KIRKLEES METROPOLITAN COUNCIL INVESTMENT & REGENERATION SERVICE

DELEGATED DECISION TO DETERMINE PLANNING APPLICATIONS

Reference No:	2024/62/90708/W
Site Address:	31, Warrenside, Deighton, Huddersfield, HD2 1LW
Description:	Demolition of existing garage and erection of replacement garage
Recommending Officer:	Molly Storer

DECISION – REFUSED

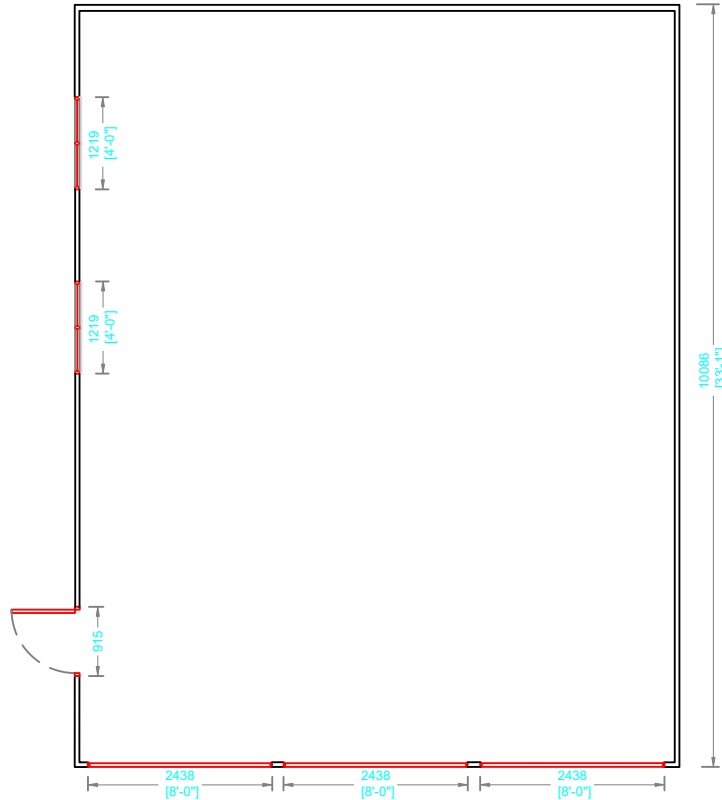
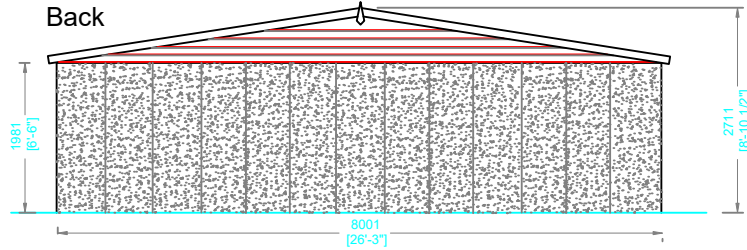
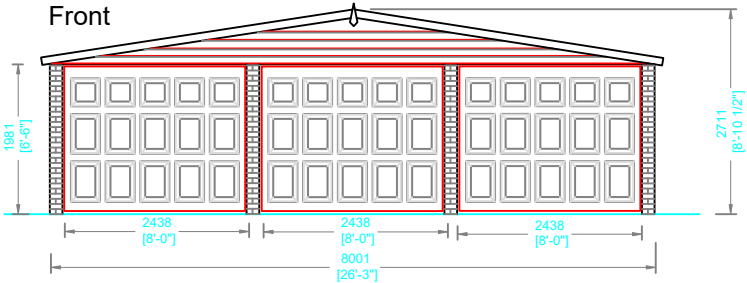
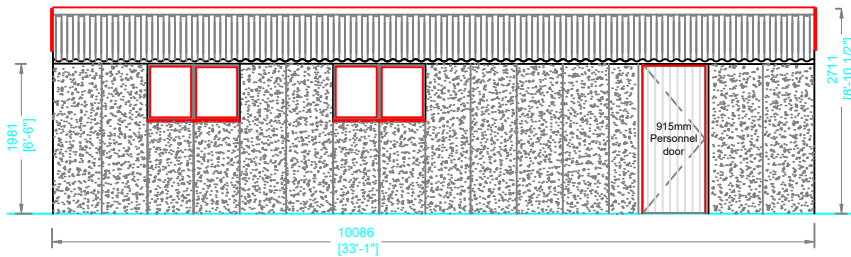
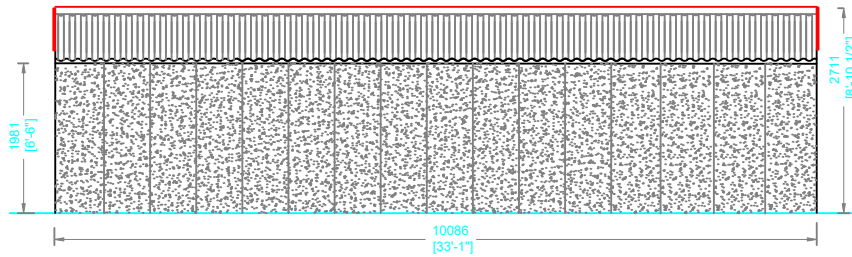
However, in this instance the proposed garage, even in relation to the large rear plot, would not be subservient to the garden this is due to the large footprint of the garage (10m x 8m). Furthermore, the original house is smaller (10m x 5m) than the proposed garage which would result in the scale of the garage dominating the original house.

The justification also stated that the proposed garage is lower than the existing two storey house and would be situated to the rear of the dwelling. However, it is considered that although the garage would be set back from the street, due to the orientation of the original house and the proposal the garage in addition to the proposal being set on a higher ground level to the street, the garage would still be visible from the street leading to a negative impact on the street scene.

The proposal is therefore considered to have an unacceptable visual impact in relation to the host property and the character of the wider locality, having regard paragraphs 5.29 & 5.30 of the House Extensions and Alterations SPD. Having taken into account the above, it is considered that the proposal would not be subservient in size and scale to the original house and would not harmonise with the surrounding development and the wider street scene, Therefore, the proposal is concluded to fail to comply with Policy LP24 of the KLP, principles 1 and 2 of the Councils House Extensions and Alterations SPD, and policies within Chapter 12 of the NPPF.

The proposed garage by reason of scale and massing, would result in an addition which would not be subservient and would dominate the host property having a harmful impact to the visual amenity of the area. To permit the proposals would be contrary to Policy LP24 of the KLP, the aims of the Councils House Extensions and Alterations SPD, and Chapters 12 and 16 of the NPPF.

1. The proposed development by reason of its design, scale and massing, would result in a development which would not be subservient to the host property and which fails to harmonise with the character of the host property and wider locality causing a harmful visual impact. To permit the proposals would be contrary to Policy LP24 of the KLP, Principles 1 and 2 of the Councils House Extensions and Alterations SPD, and policies within Chapter 12 of the National Planning Policy Framework.
